## Swept Path Analysis Response

OC 302 MILK STREET Scale 1:100 @ A0

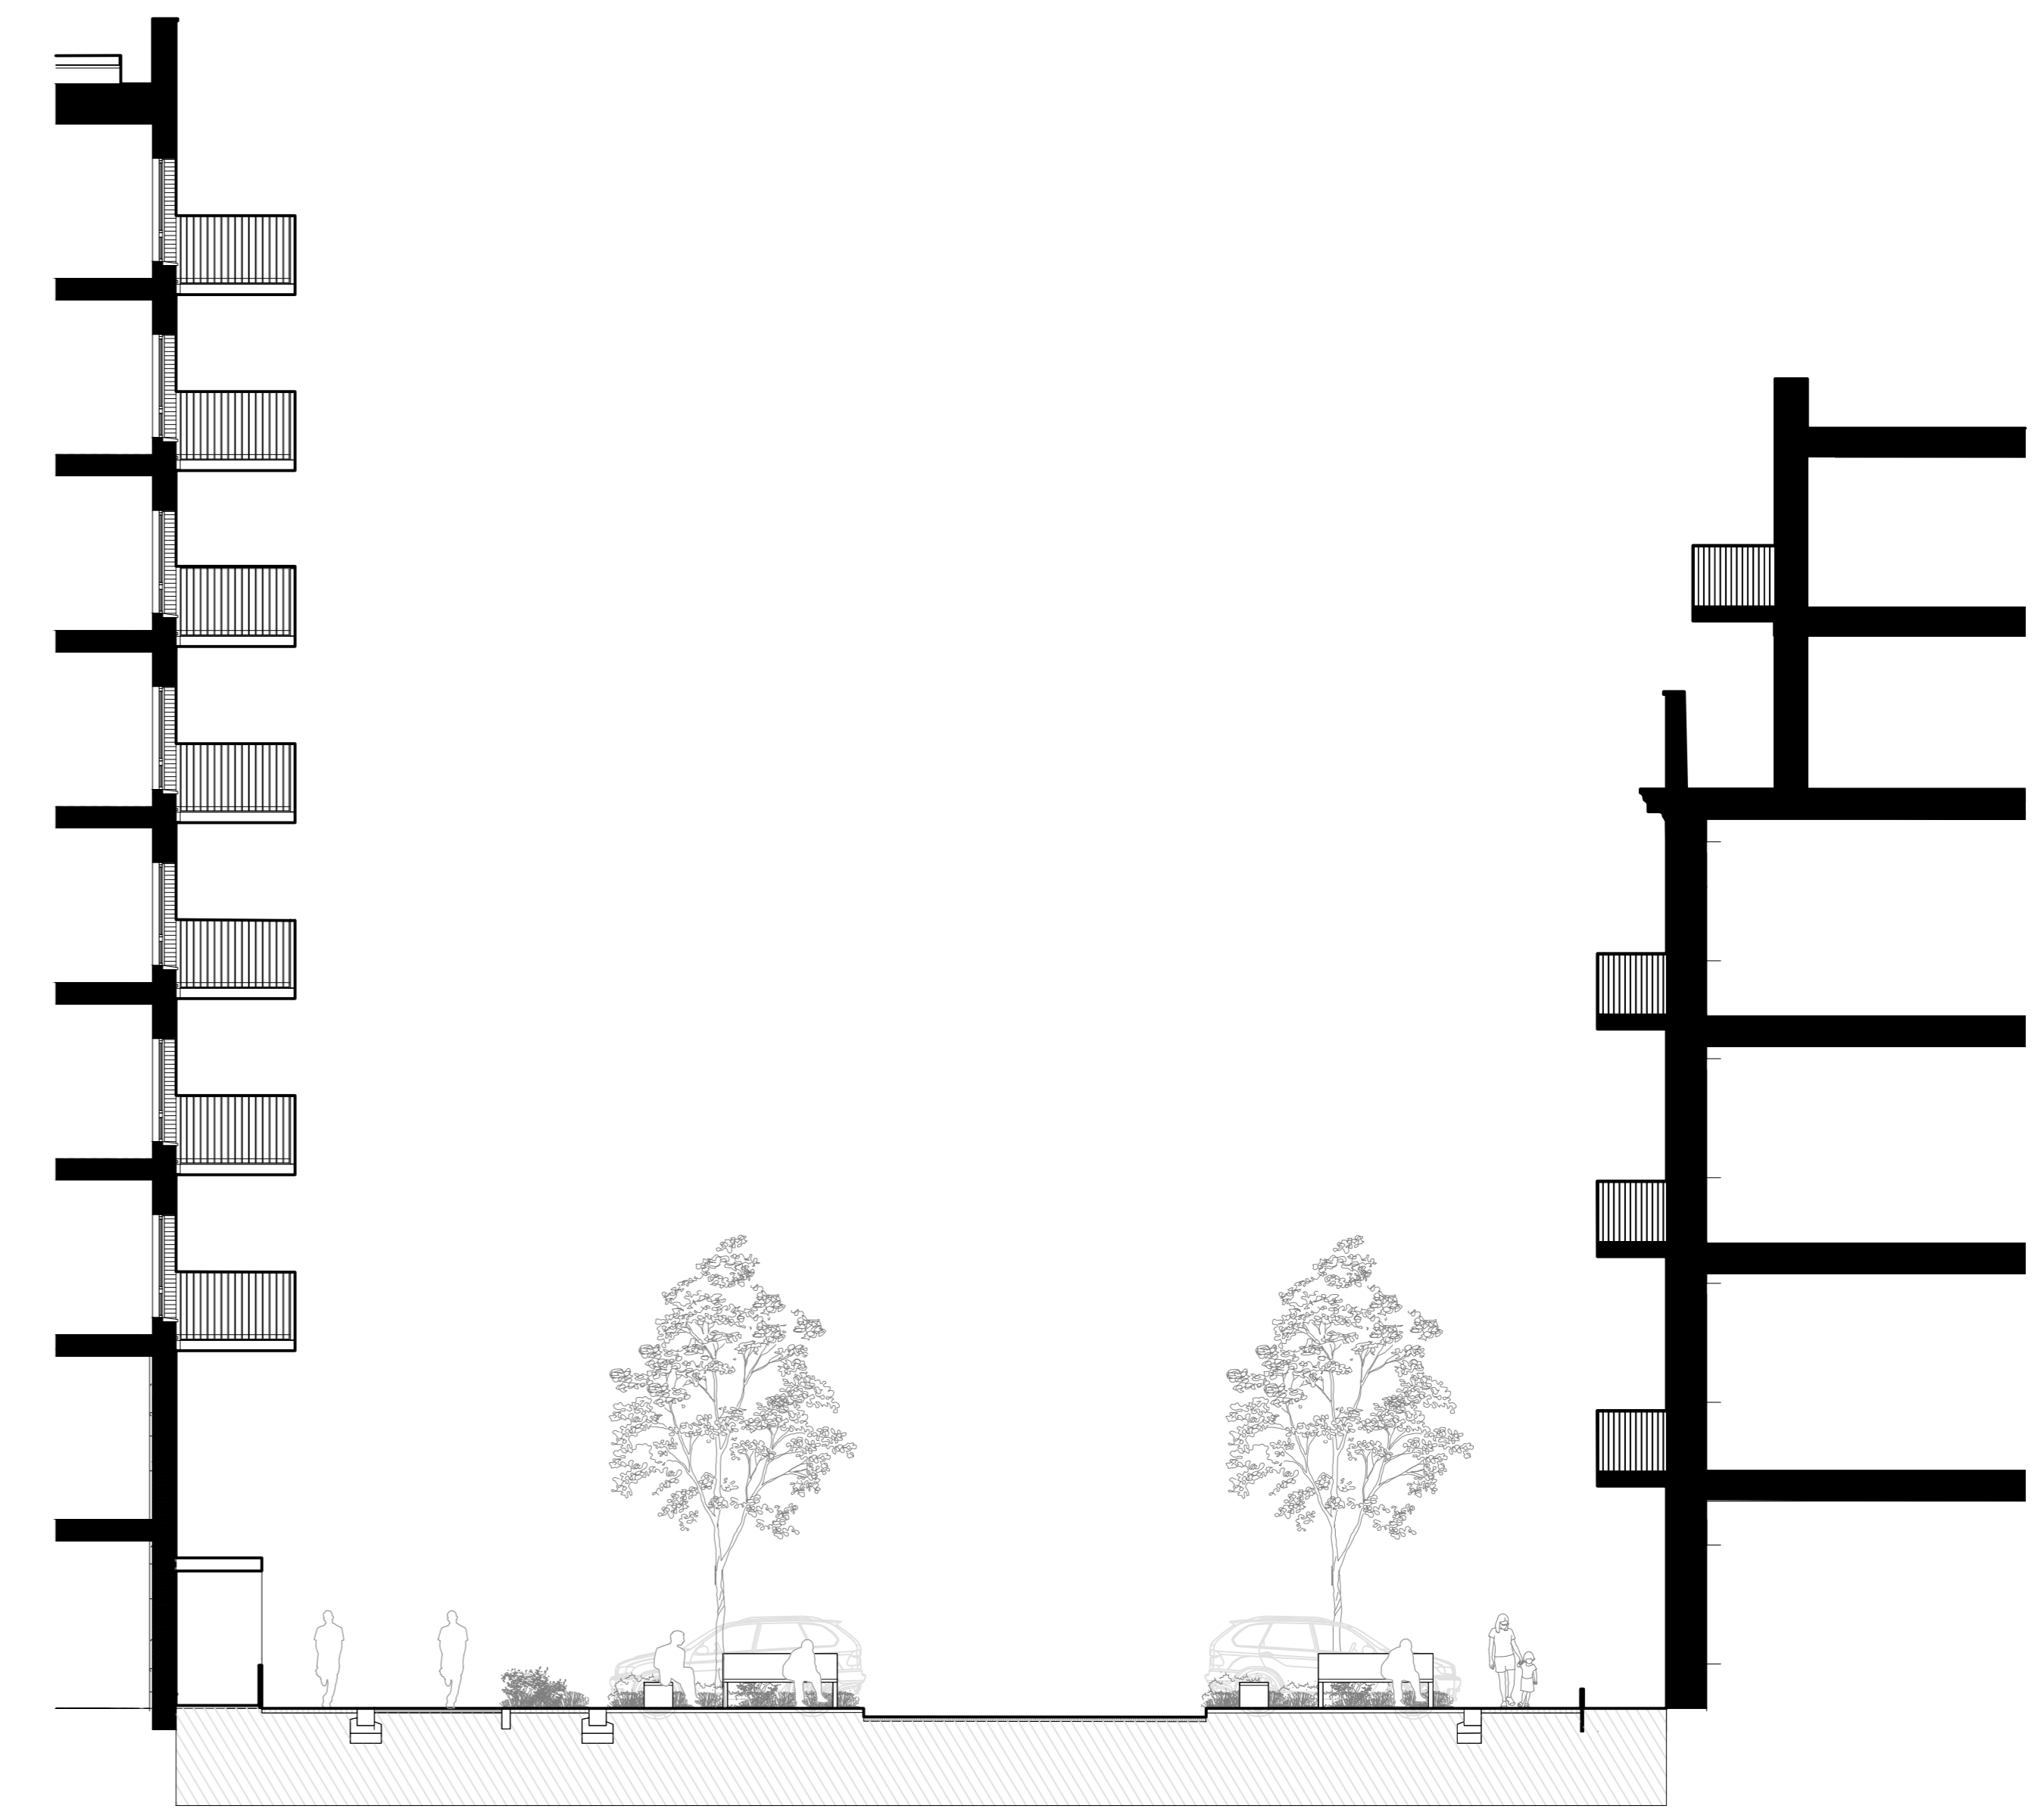
There is no vehicle tracking for cars with trailers along Sandow Yard / Canal Mews, Milk Walk, Viveash Walk, Wallis Walk (by Block G) or Milk Street. All these streets have car parking spaces, so inevitably they will be regularly used by cars. It's important to see the vehicle tracking for these parts of the site too.

*All of the locations where end-on car parking is provided have carriageway widths of 6m to enable access in and out of the bays. This includes all of Milk Street, Canal Street, Sandown Yard / Canal Mews, Milk Walk and Viveash Walk. There is therefore no need to provide vehicle swept paths for cars on these route as they are more than sufficient for two-way car movement.*
